Permit No: 01-0212	Issue Date: MAR 26 2001	CBL: A002001
Owner Name: McAllister Farms LTD	Contractor Name: Tri-R-Erection	Phone: 781-958-0909
Contractor Address: 18502 Forest Elms Drive Spring	Phone: 2813556137	
Permit Type: Alterations - Commercial		Zone: F-M

BUILDING PERMIT REPORT

DATE: 21 MARCH 2001 ADDRESS: 324 Riverside Street CBL: 317-A-002

REASON FOR PERMIT: To install rack storage for auto glass

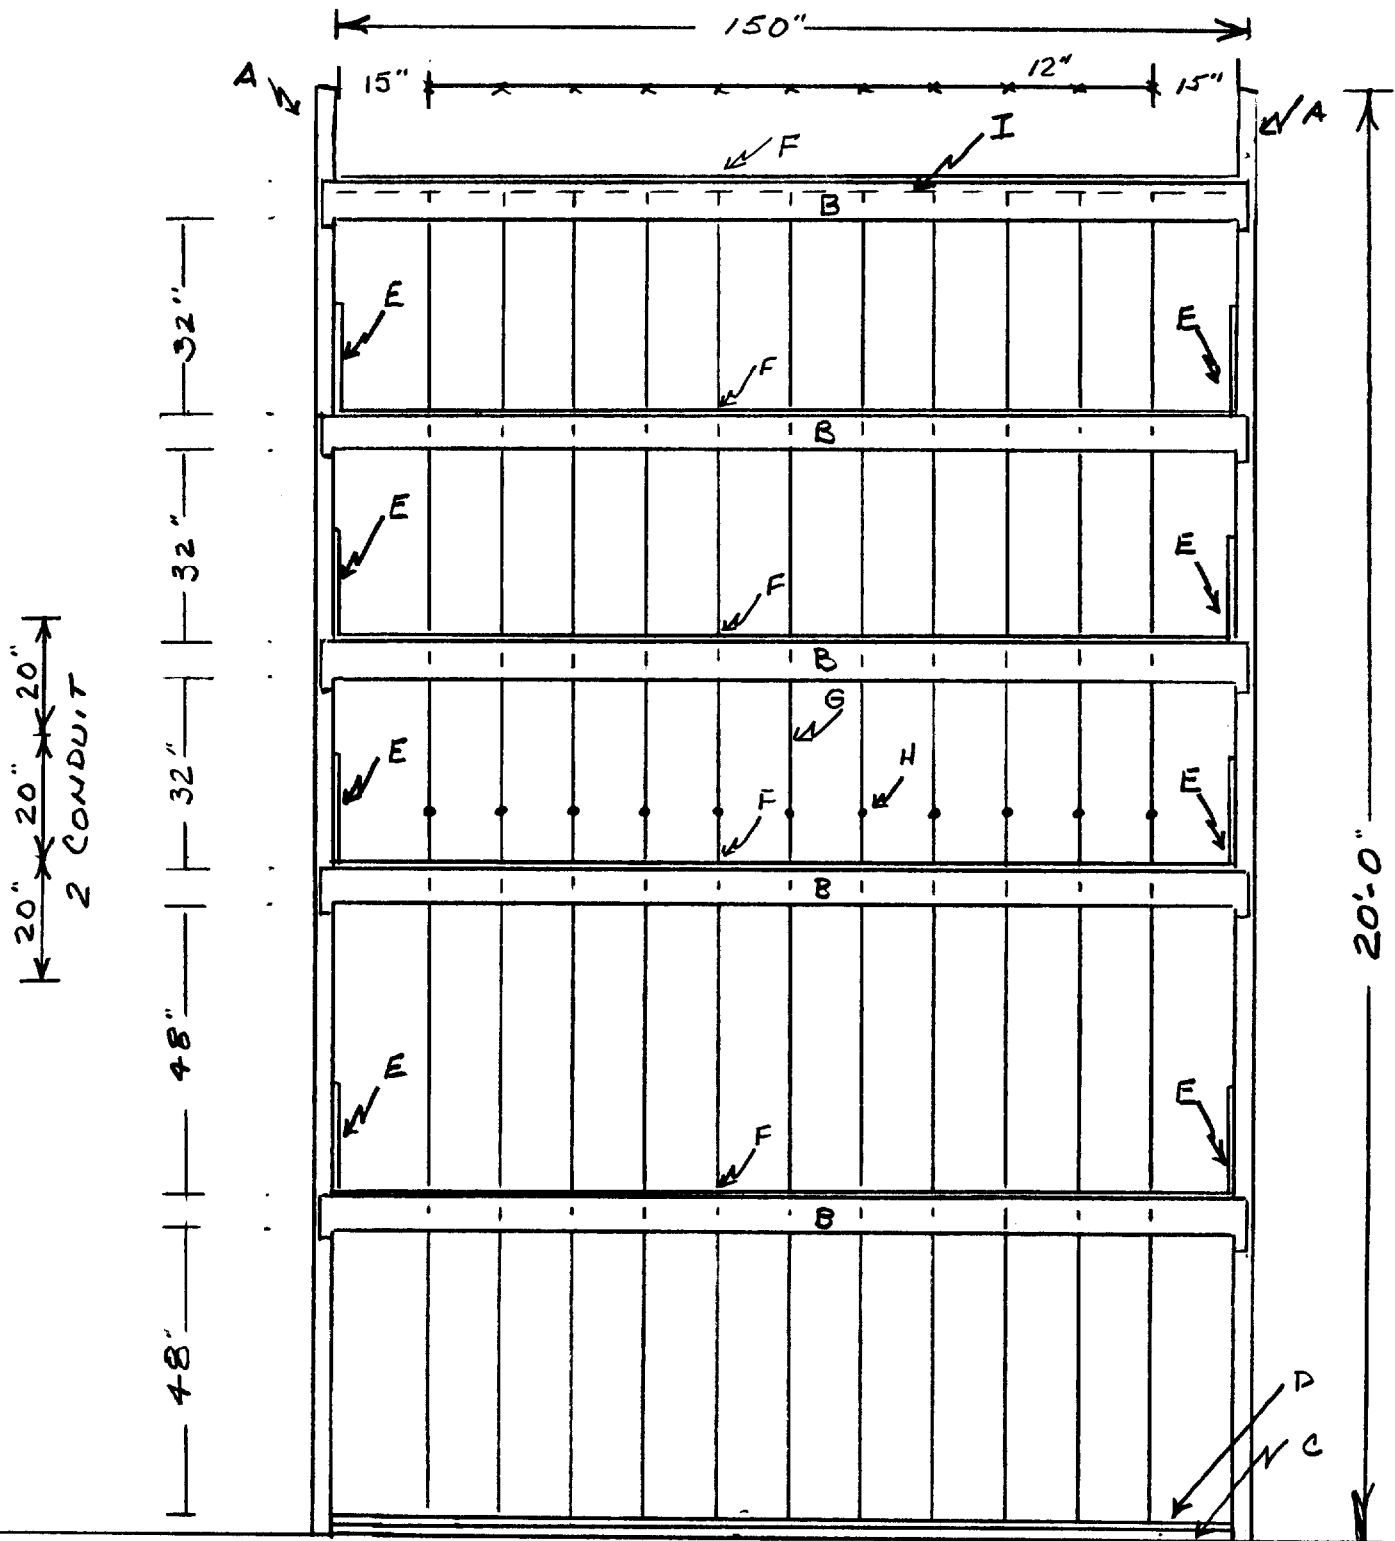
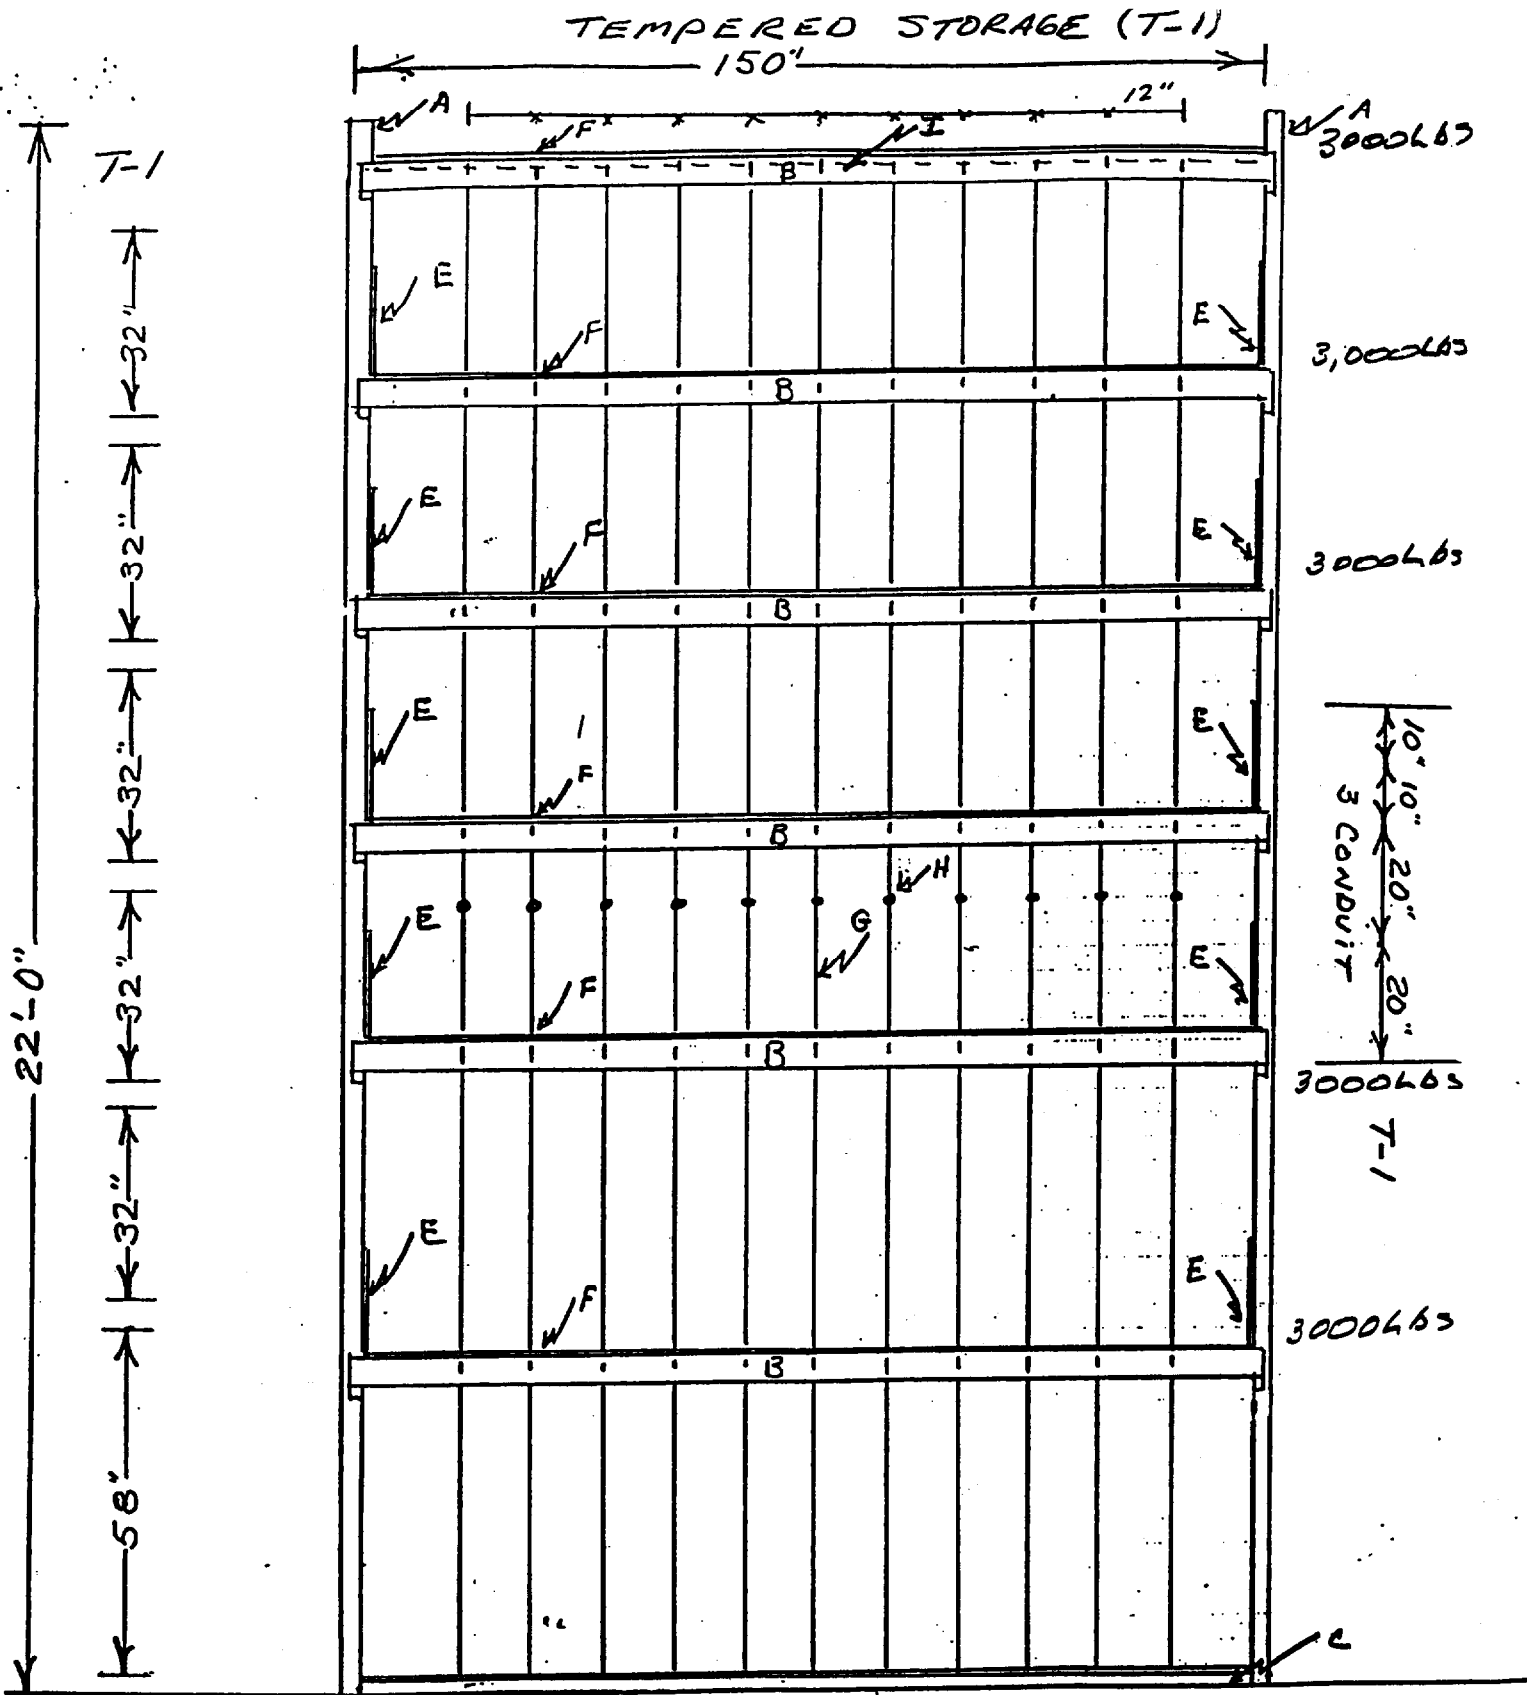
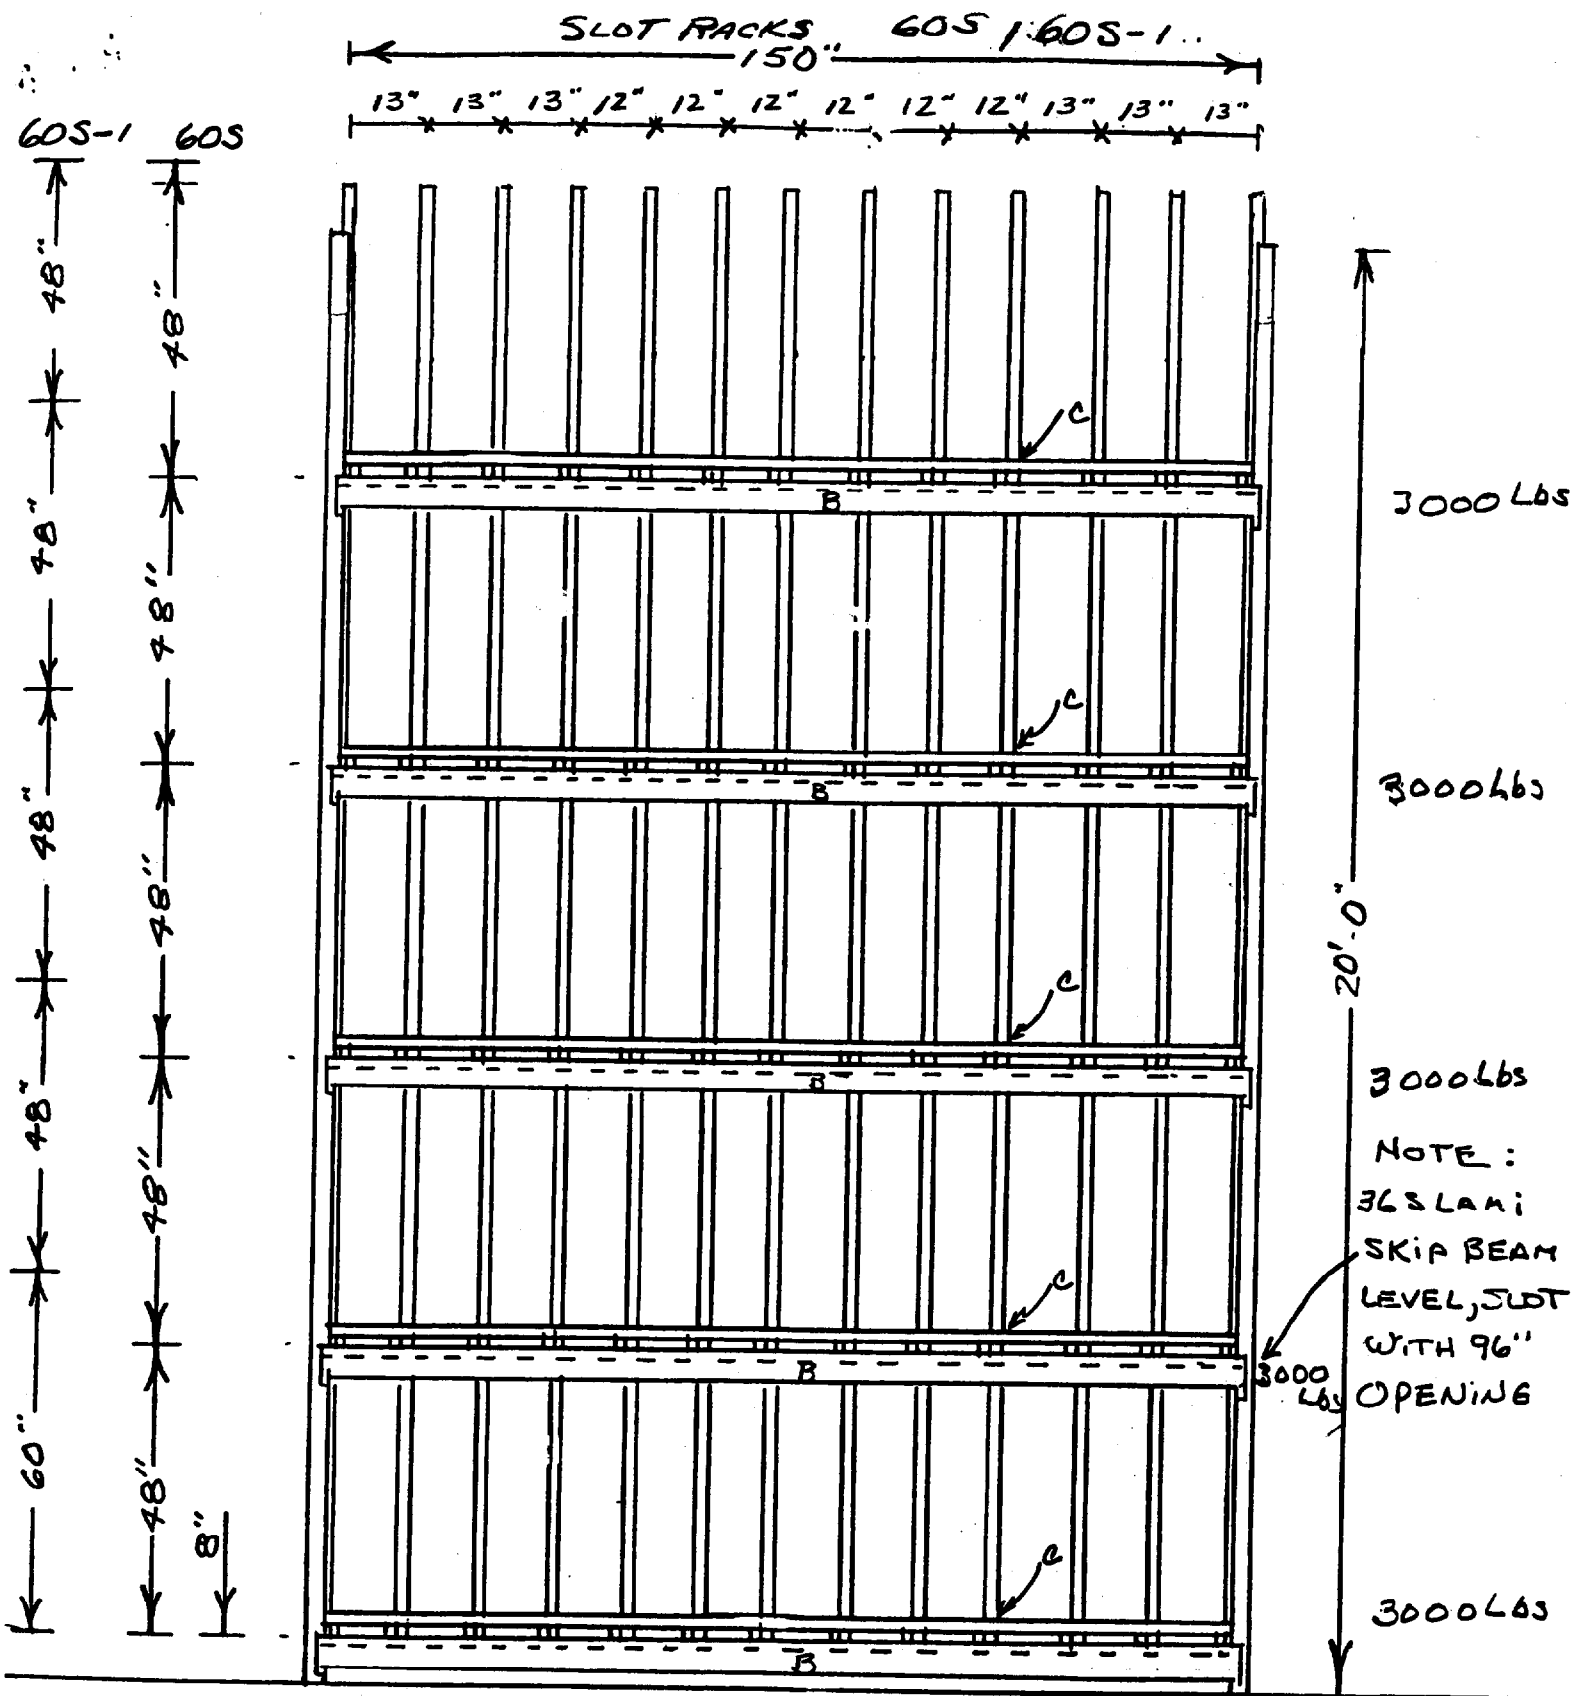
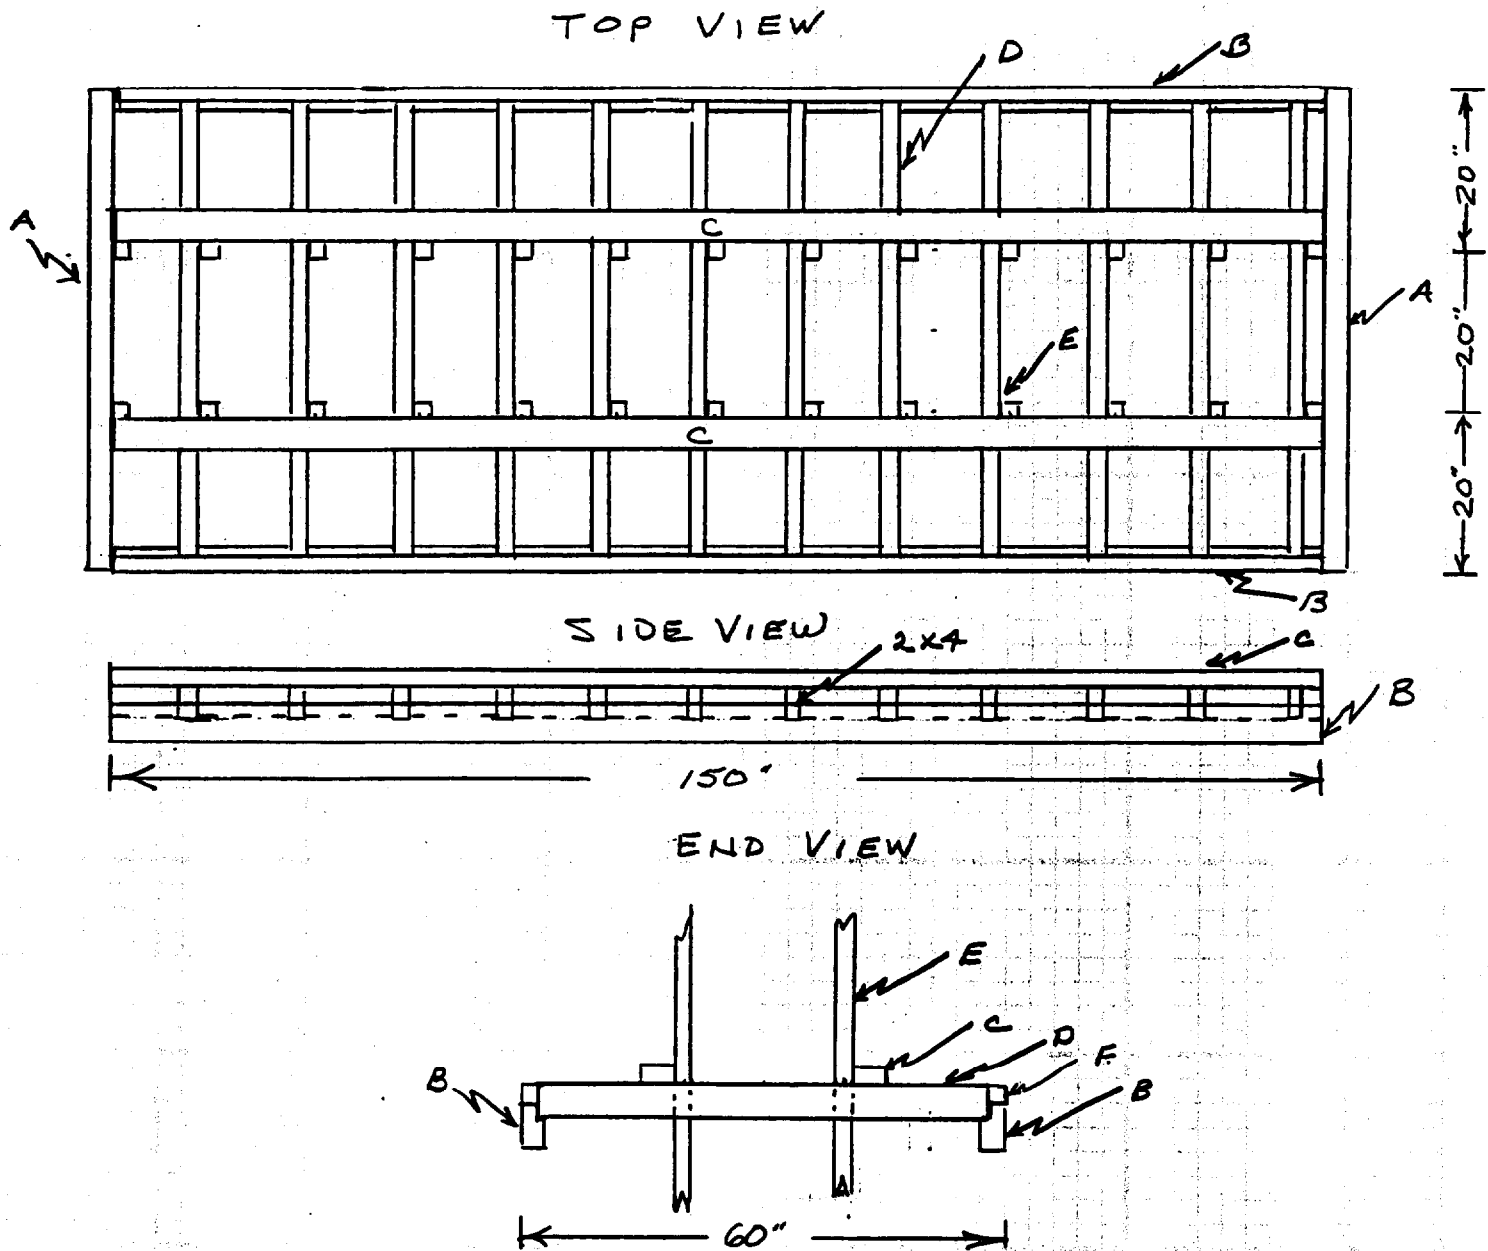
*38. Storage racks shall comply with Section 422.0 of the City's Building Code.

*39. BOSCH METAL BUILDING CODE 1999
Your plans submitted did not show nor bear the seal or signature of a professional engineer on the design of the racks and capable of the racks to carry the loads placed on them. Please submit this in format.
